<b>Application Ref:</b>	3/2026/0217			 <b>Ribble Valley Borough Council</b> <a href="http://www.ribblevalley.gov.uk">www.ribblevalley.gov.uk</a>
<b>Date Inspected:</b>	28/04/2026	<b>Site Notice:</b>	28/04/2026	
<b>Officer:</b>	MC			
<b>DELEGATED ITEM FILE REPORT:</b>				<b>REFUSAL</b>

<b>Development Description:</b>	Reserved matters application relating to appearance, landscaping, layout and scale following outline planning permission 3/2025/0289.
<b>Site Address/Location:</b>	Thornley Hall Farm, Up Bedlam Road, Thornley, PR3 2TN

| Title: Proposed Plans | |

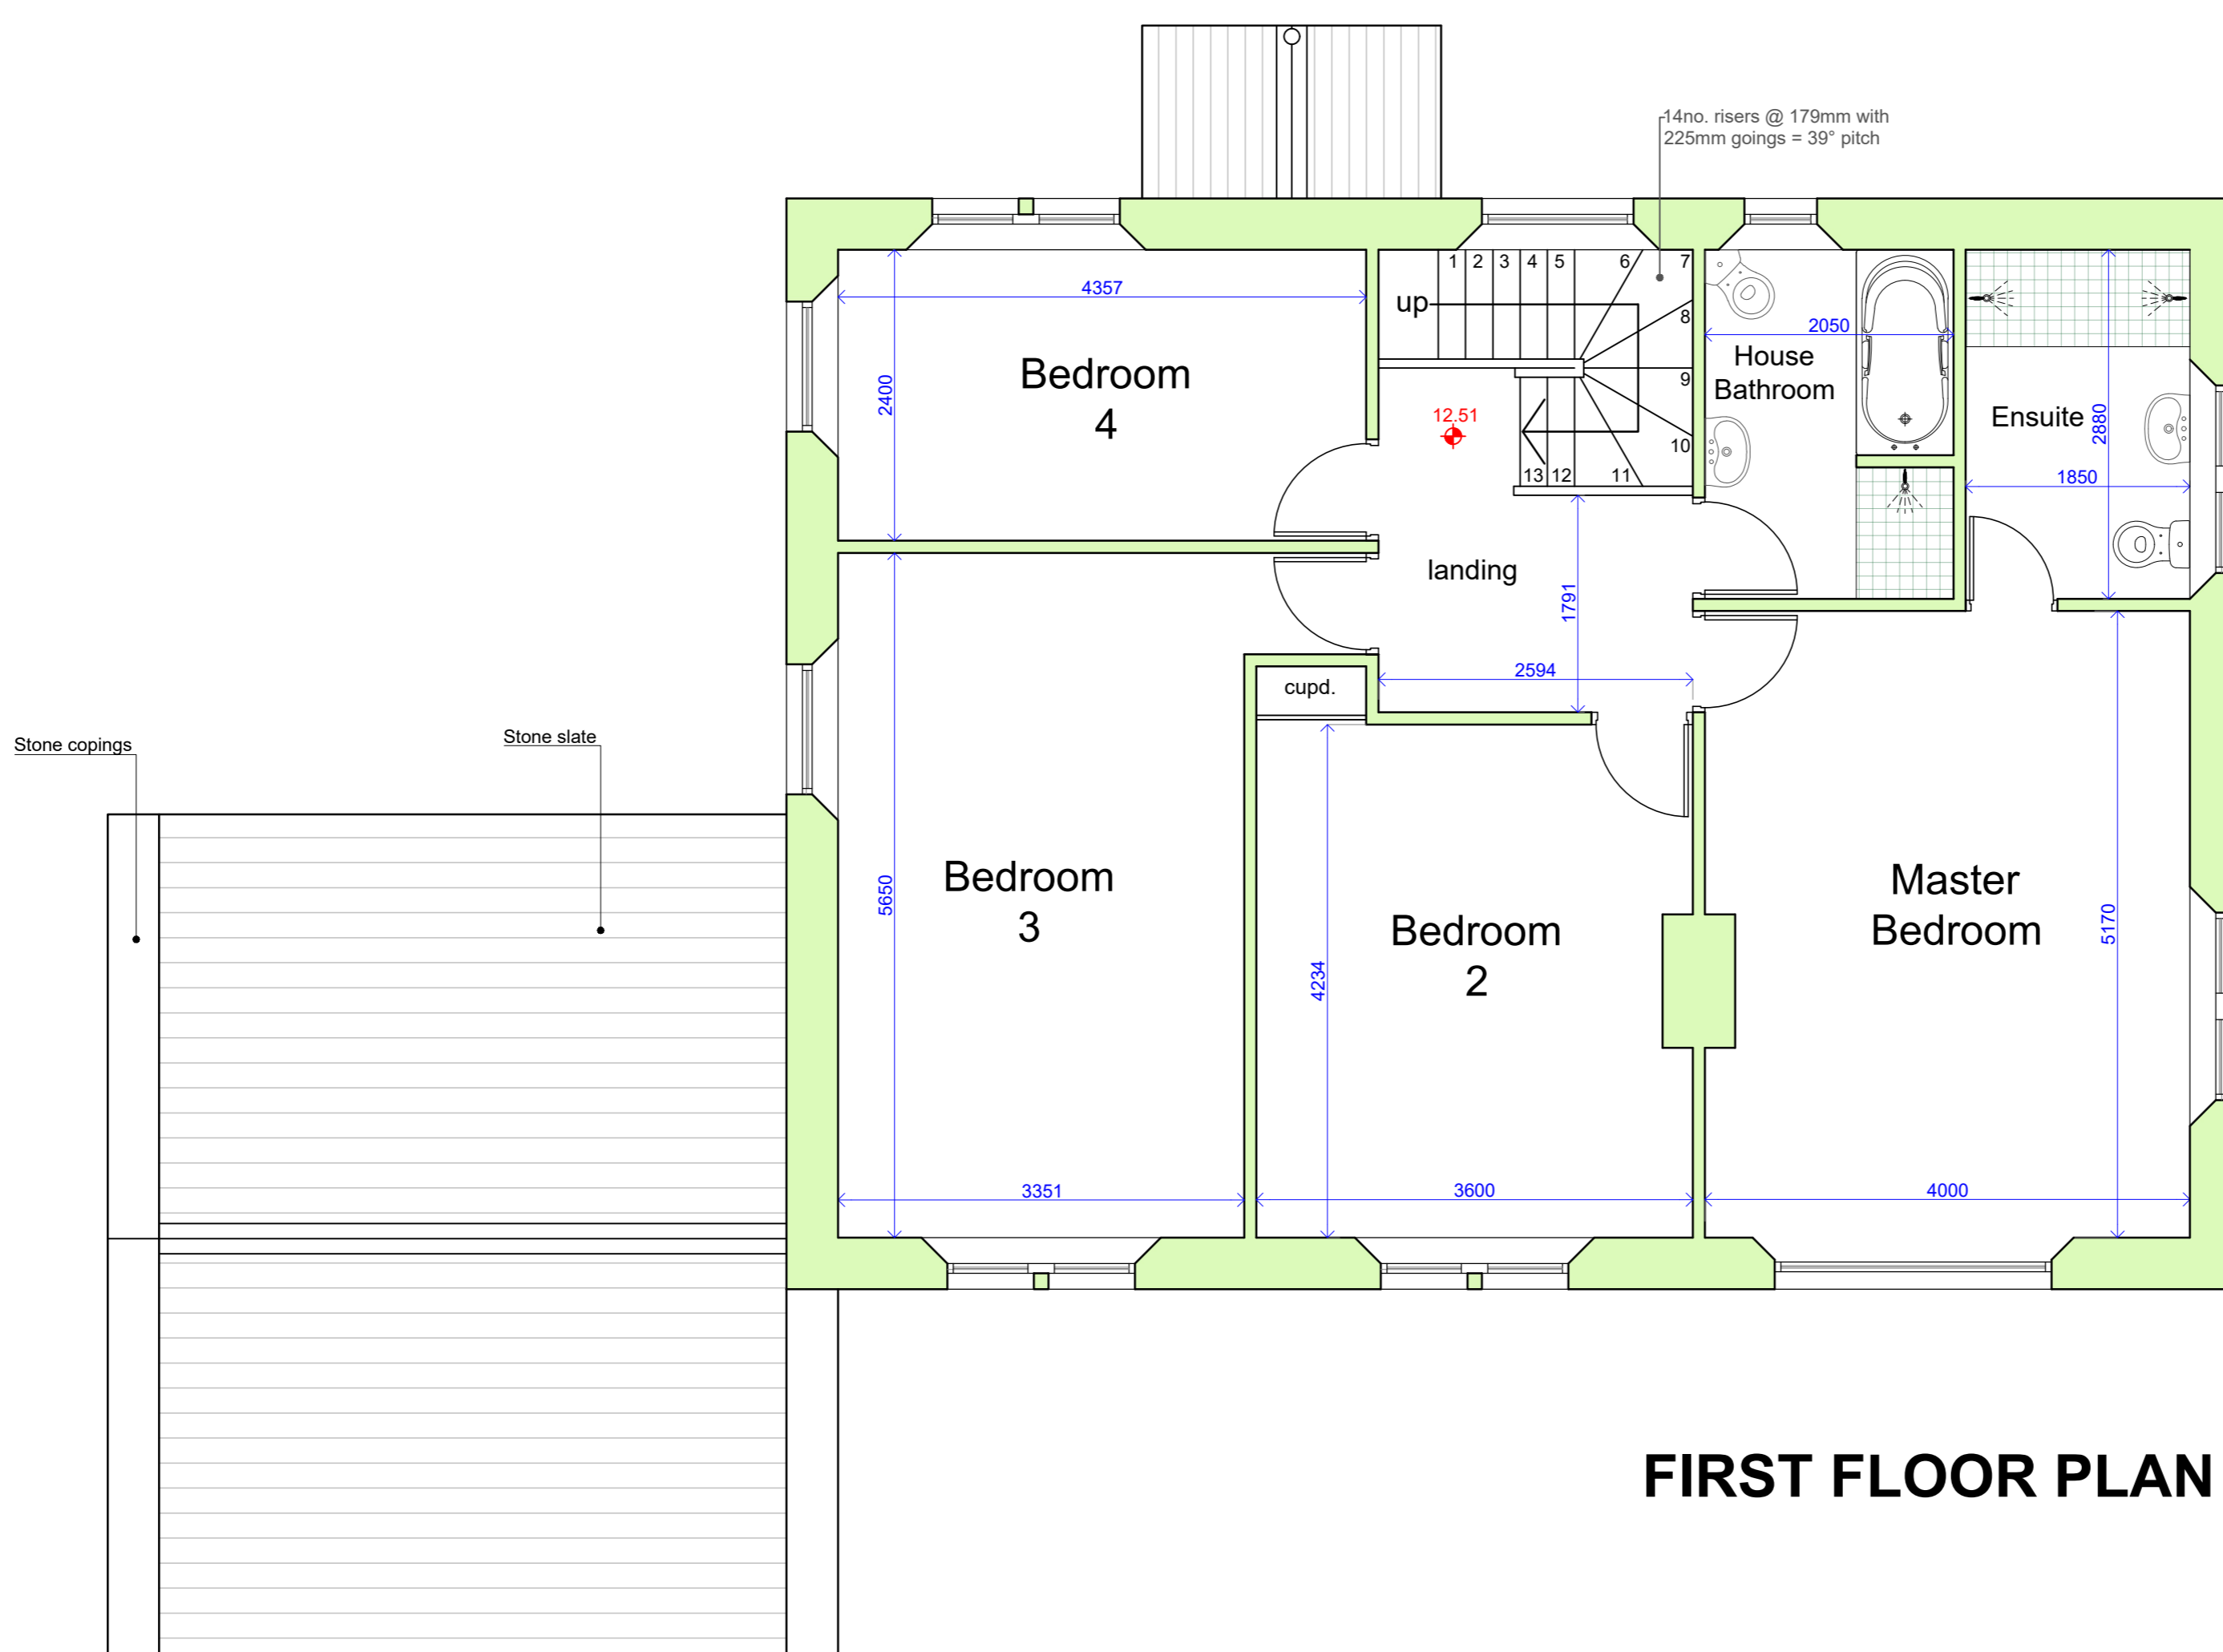
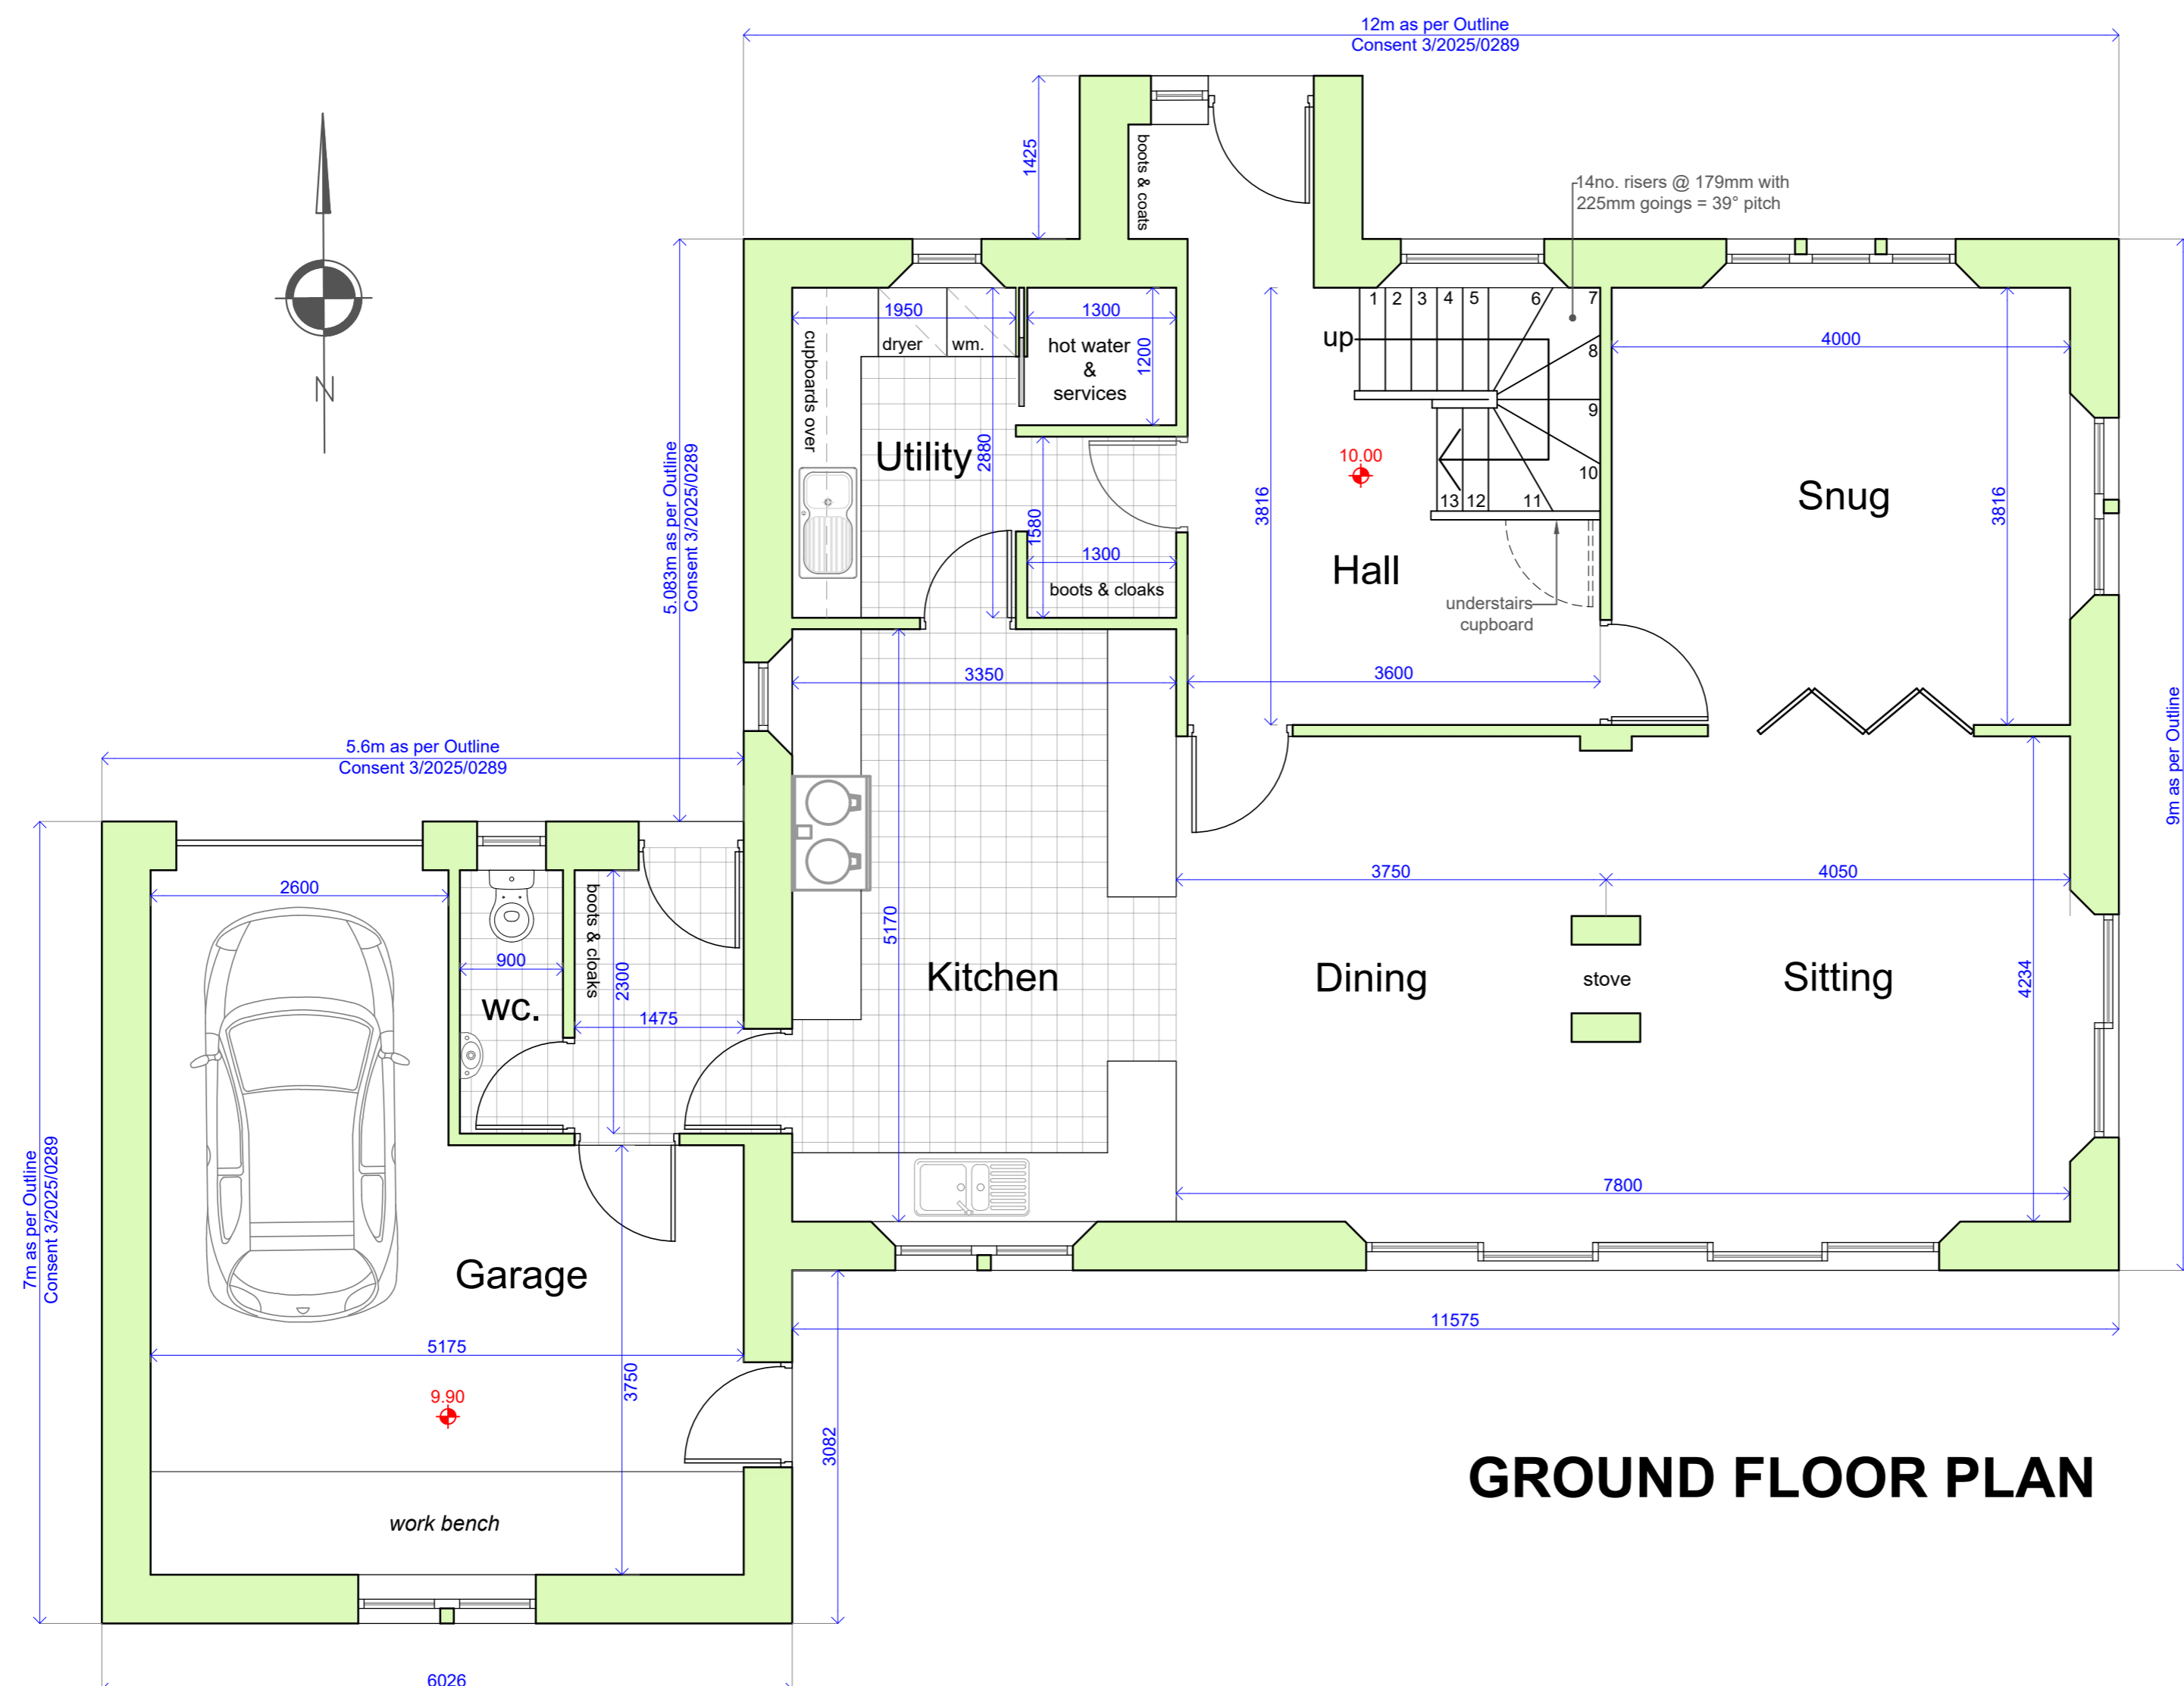
With regards to parking/turning, they note that the area inside the garage where a car is shown to be parked, would not meet the internal size requirements which should be approximately 3m x 6m. However, the driveway could provide adequate parking for up to 3 no. vehicles and allow room to turn. As such, this would not warrant refusal of the application.
